**APPLICATION BY SUFFOLK COUNTY COUNCIL FOR AN ORDER GRANTING
DEVELOPMENT CONSENT FOR THE LAKE LOTHING THIRD CROSSING**

PLANNING INSPECTORATE REFERENCE NUMBER TR010023

CLOSING POSITION STATEMENT ON BEHALF OF:

DATED: 4 JUNE 2019

**MAINLINE LONG SECTION
(WORK NOS. 1A, 1B, 1C, 1D & 1E
WORKS PLANS SHEET NOS. 1 & 2)**

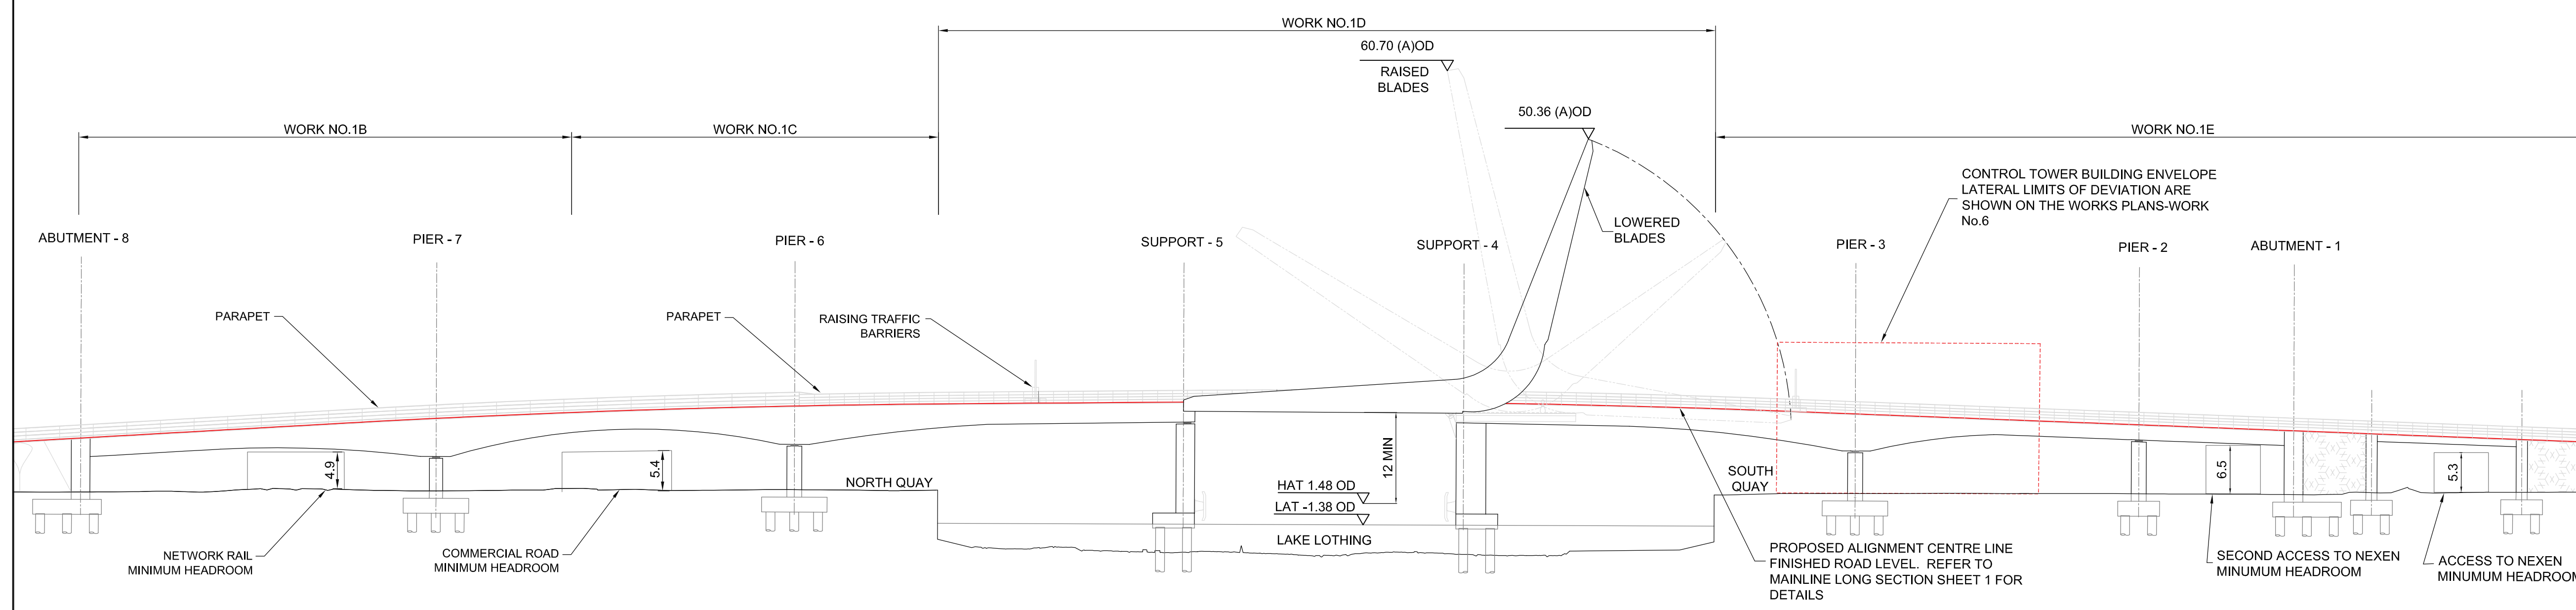
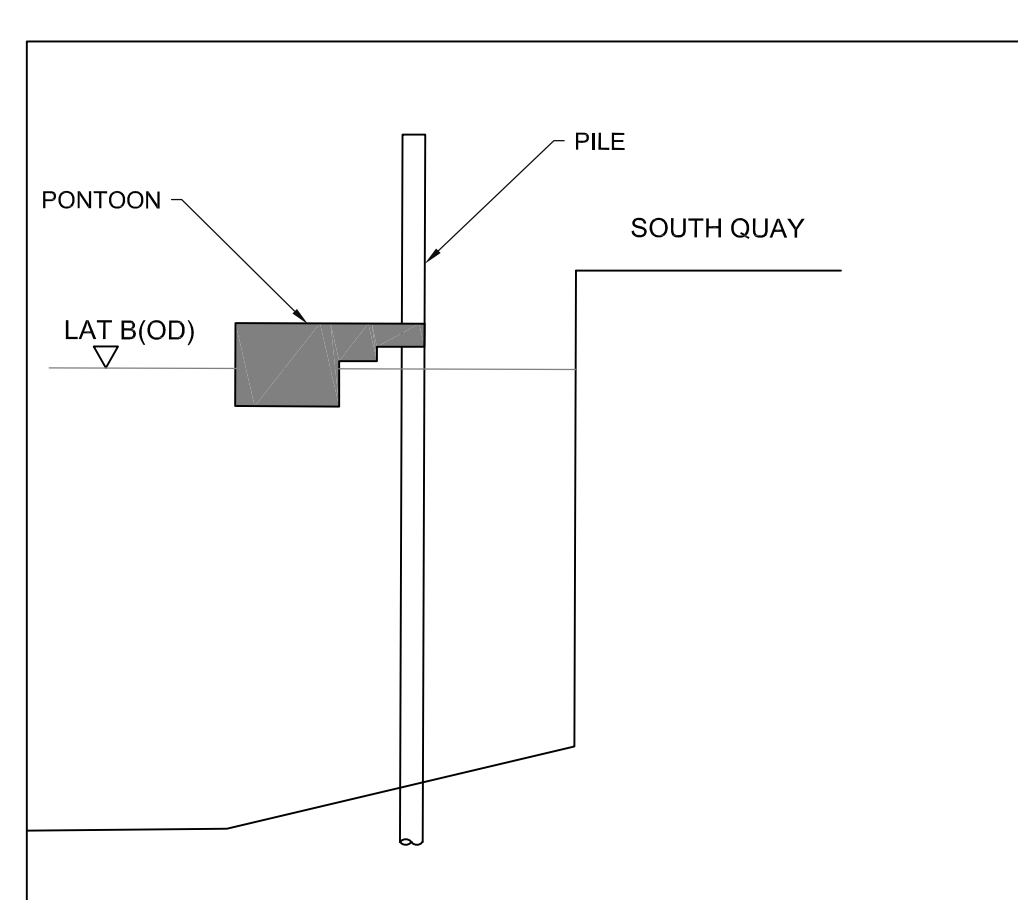
- 12.1 Given the importance of the height of the proposed underpass to our clients' businesses during the operational phase of the project, the limits of deviation allowed for in Part 2 Article 5 of the draft DCO for Work No. 1E should ensure that no vertical deviation below the minimum clearance height of 6.5m will be permitted. At present we note that a downward vertical limit of deviation of 1.1m is provided for.

- 12.2 It was explained that since the first written representations on 8 January 2019 the Nexen Group have been seeking clarity in Article 5 of the draft DCO for the minimum underpass clearances to be set out in the draft DCO and for the current allowances for a 1.1m downward vertical limit of deviation for Work No. 1E to be removed.

- 12.3 At the hearing on 14 May 2019, the Applicant indicated that such a change was not necessary as the works were set out in engineering drawings.
- 12.4 However, the "engineering section drawings and plans" are the plans to which the limits of deviation in Article 5 of the draft DCO relate. As a result, reference to such drawings does not provide the Nexen Group with any comfort.
